**Re: Gatewood Apartments, 6300 Montgomery Blvd., Grading and Drainage Plan
Engineer's Stamp dated 9-22-03 (G18/D46)**

**RE: Grading and Drainage Plan for Gatewood Apartments Paving (G17-D40) Dated
October 8, 2003**

RE: RESPONSES TO YOUR COMMENTS FOR THE GRADING AND
DRAINAGE PLAN FOR GATEWOOD APARTMENTS, 6300
MONTGOMERY BLVD NE, ENGINEER'S STAMP DATED 09-22-03,
(G-18/D46),

FILE: 630101 - GATEWOOD APARTMENTS BASE.dwg 	<b>DRAINAGE PLAN</b> <b>FOR</b> <b>GATEWOOD APARTMENTS</b>  Applied Engineering & Surveying, Inc. 1028 BLAIR DRIVE NE ALBUQUERQUE, NEW MEXICO 87112 Ph: (505)237-1406	DATE/REVISION:  SHEET NUMBER: 1

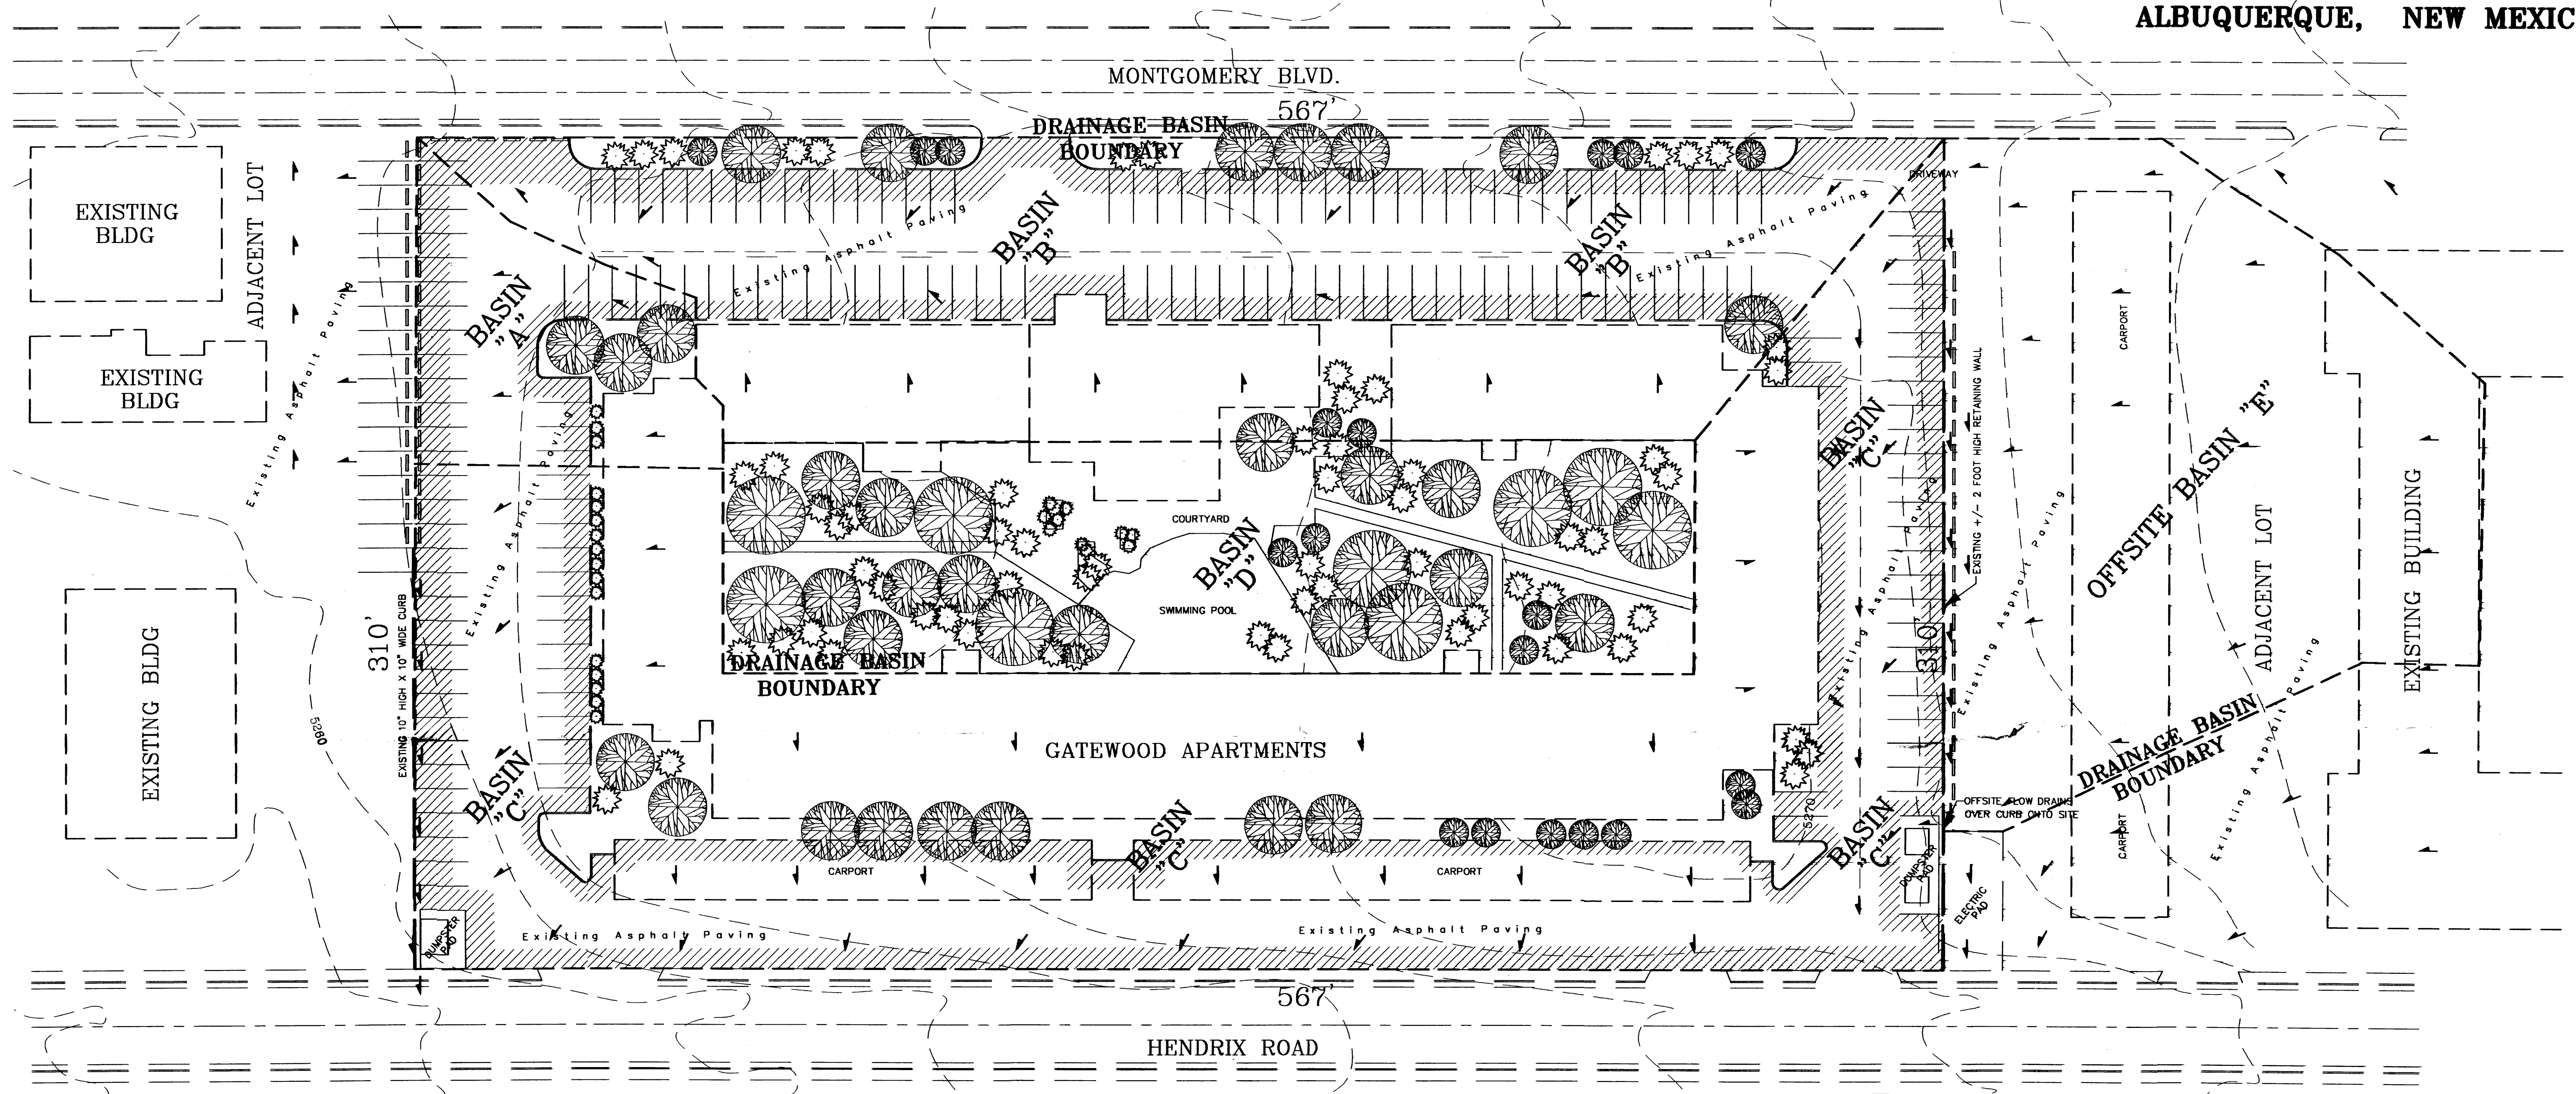
1. Please include a benchmark for reference.
2. Notes regarding offsite flows reference attached calculations; however, these calculations do not appear to be attached. Please define the offsite flow.
3. Include spot elevations.
4. Please define the work limits for asphalt replacement.

1. A note was added that the topographic information shown on this drawing was based on aerial topographic survey from the City of Albuquerque, and no bench mark should apply.
2. Offsite calculations are shown on drawing sheet number 2, see narrative "Offsite Drainage Basin E".
3. The topographic survey from the City of Albuquerque does not show spot elevations.
4. The limits of asphalt replacement is now shown on sheet 1
